Memo: 30th October 2014

To: Urban Growth % NPC
Att: Craig Kelly
Re: **Response to M2 Site SSDA Submissions – Traffic & Transport Issues**

Further to our discussions, and receipt of submissions relating to the recent M2 Site State Significant Development Application (**SSDA**), ARC Traffic + Transport (**ARC**) has reviewed those submissions relating to the access, traffic and parking characteristics of the SSDA. A response in regard to each submission is provided below.

VEHICLE SWEEP PATHS – VIEW 1
WICKS, WATERLOO AND SPINE STREET INTERSECTION

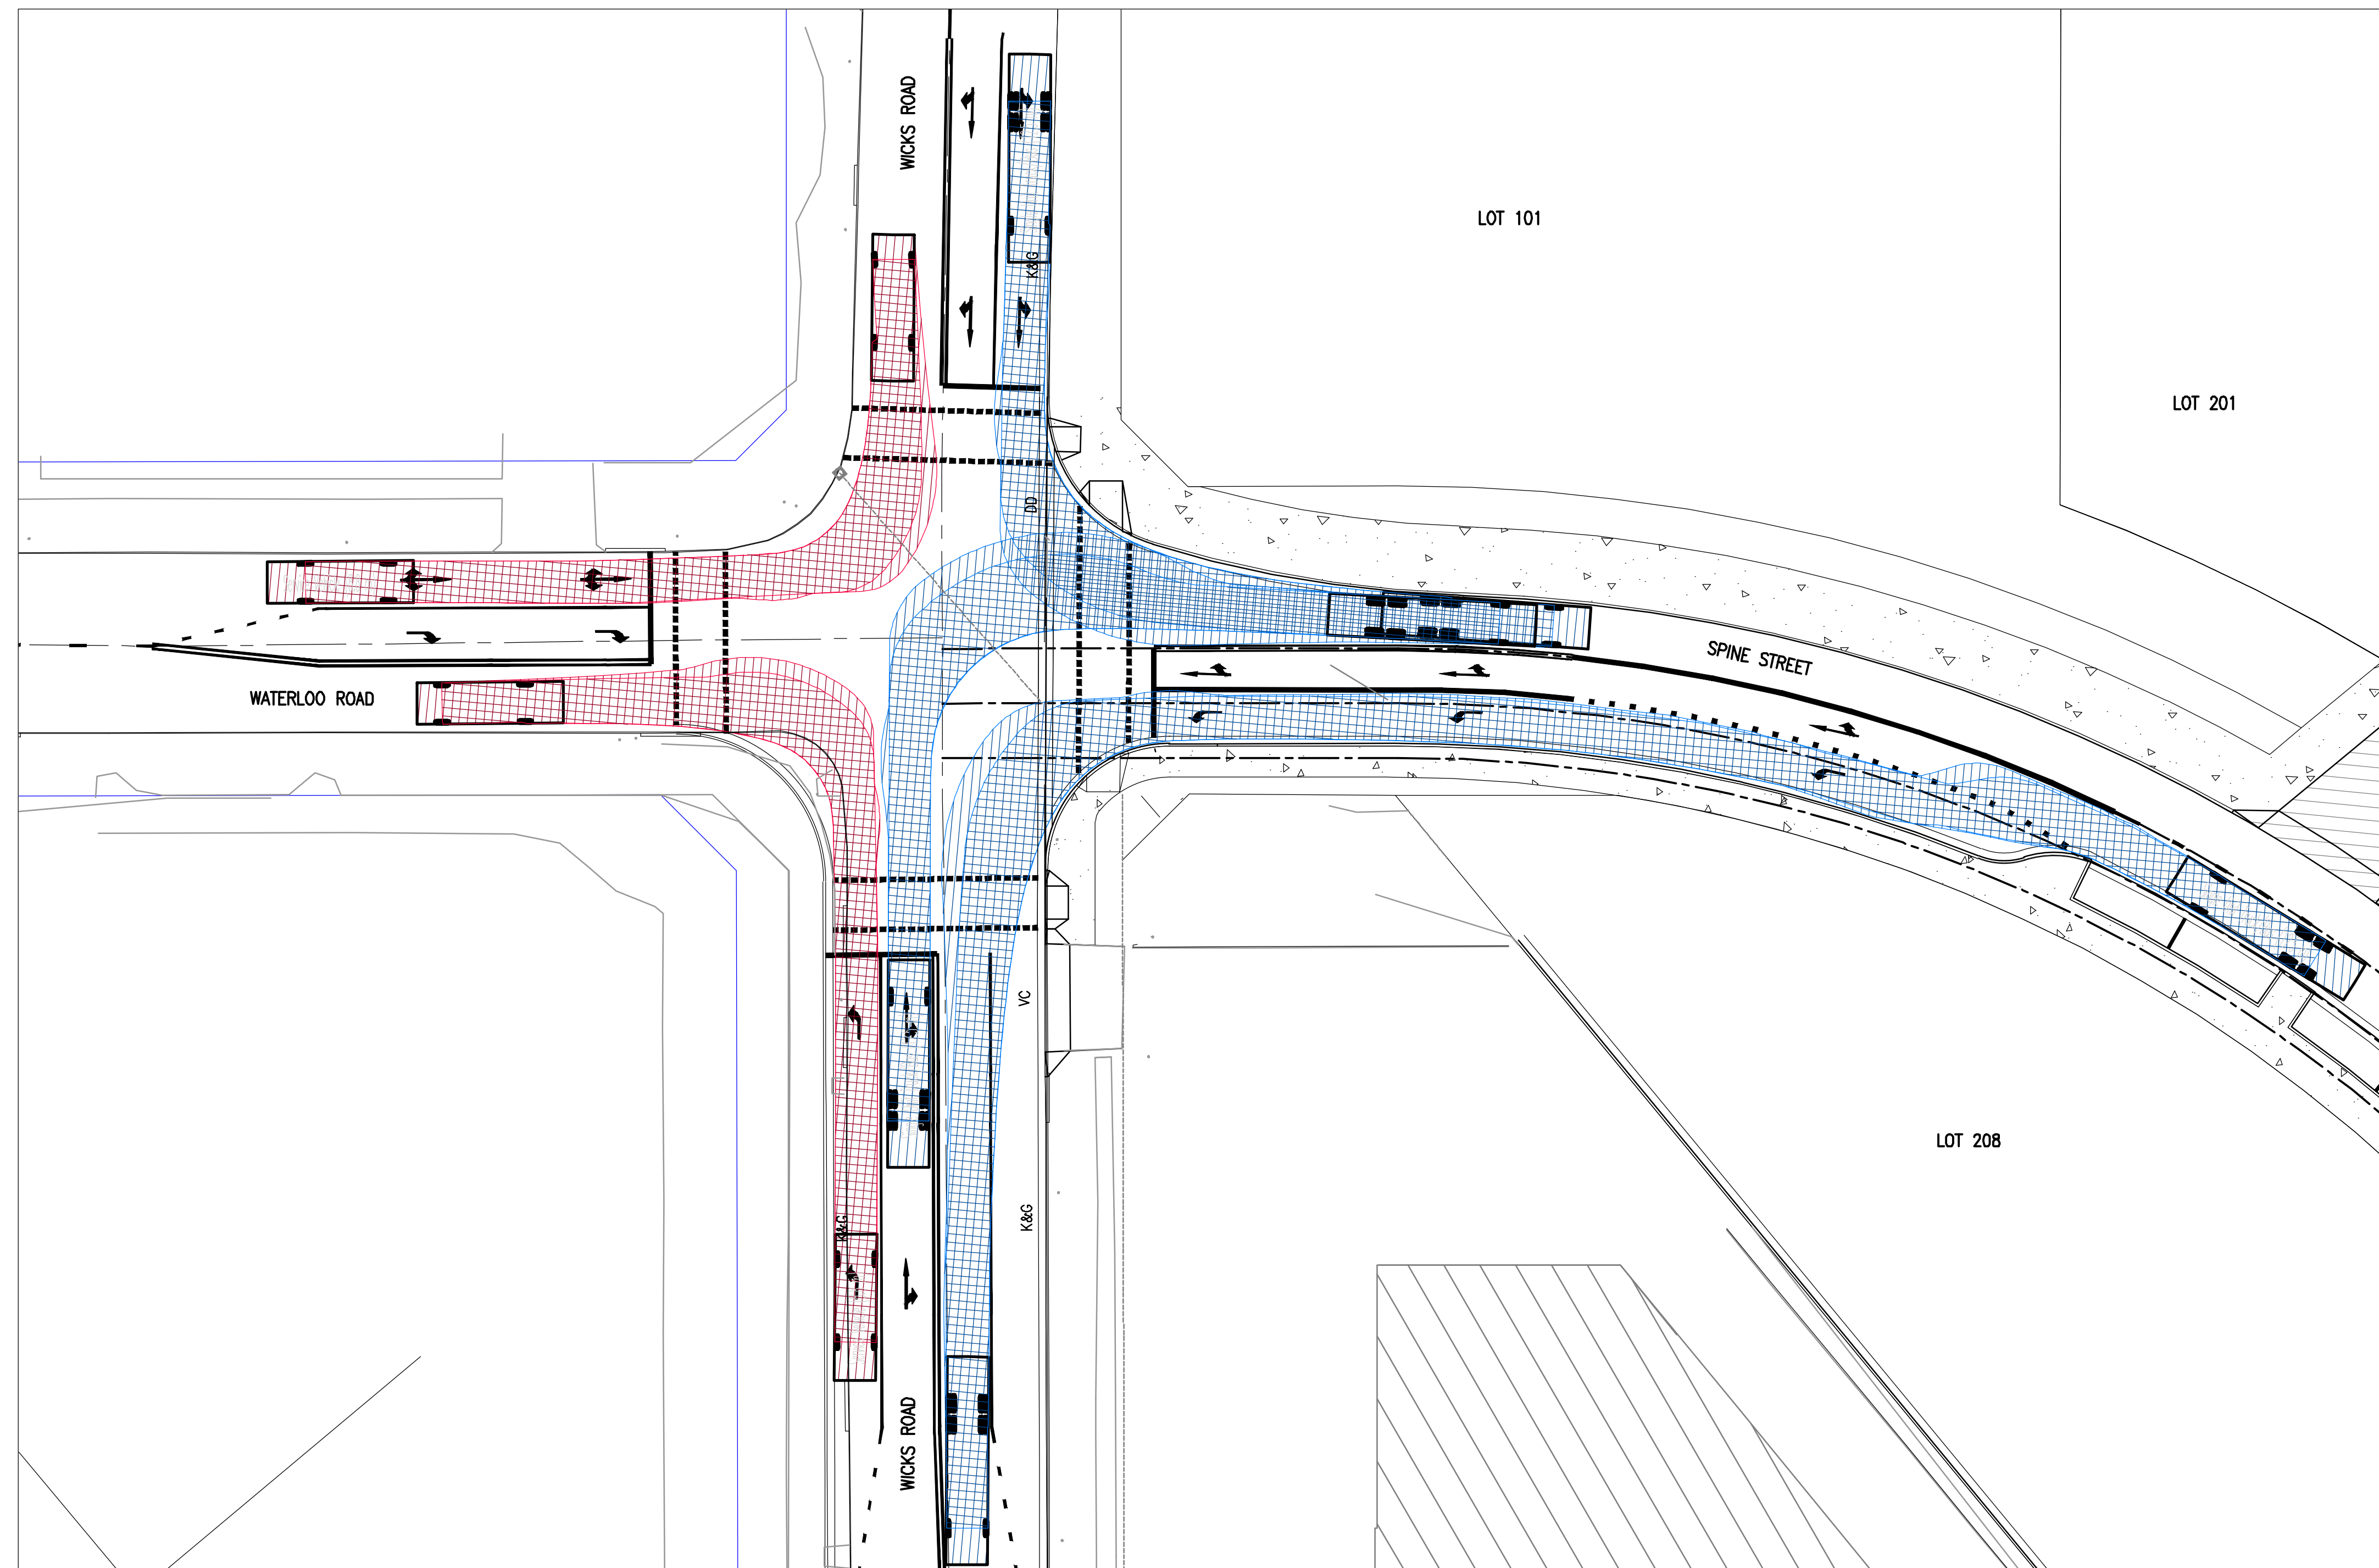
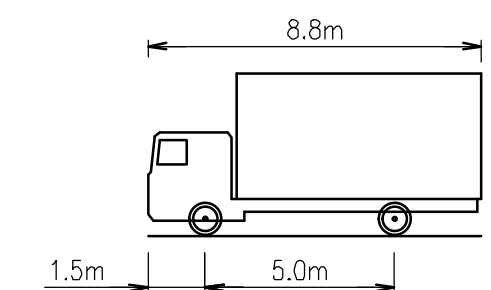
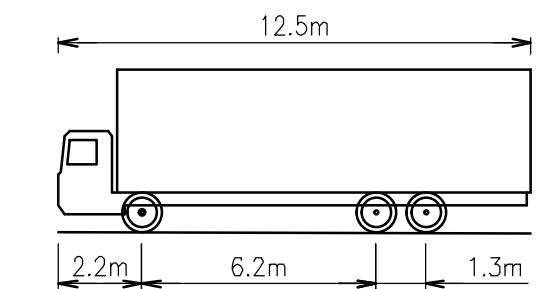
The intersection of Waterloo Road & Wicks Road & Spine Road is to be upgraded as part of the SSDA at the cost of Urban Growth. The intersection will be under signalised control, with additional lanes and the majority of cycle time dedicated to the existing key movements, Waterloo Road west to Wicks Road southbound; and Wicks Road south to Waterloo Road westbound. Further to the upgrade, the intersection is forecast to operate at a good level of service through 2031. (See also [RMS Response 1.3](#) above)

The signal phasing at this intersection will specifically provide maximum green time to the primary movements Wicks Road south left to Waterloo Road west; and Waterloo Road west right to Wicks Road south. Again, the broader design includes consideration of these primary demands, as well as factors such as pedestrian crossing demands and times (across all approaches) and will only be finalised further to RMS approval of signal design plans. (See also [RMS Response 1.3](#)).

The design of the signalised intersection of Wicks Road & Waterloo Road & Spine Road will be finalised with reference to relevant standards, including but not limited to: -

The design will also incorporate the recommendations of a detailed **Road Safety Audit** prepared by GTA Consultants in regard to the Concept Design for the intersection. Ultimately, certified copies of the signal design plans – to be prepared by a suitably qualified practitioner – will necessarily be provided to the RMS for approval prior to any construction work commencing.
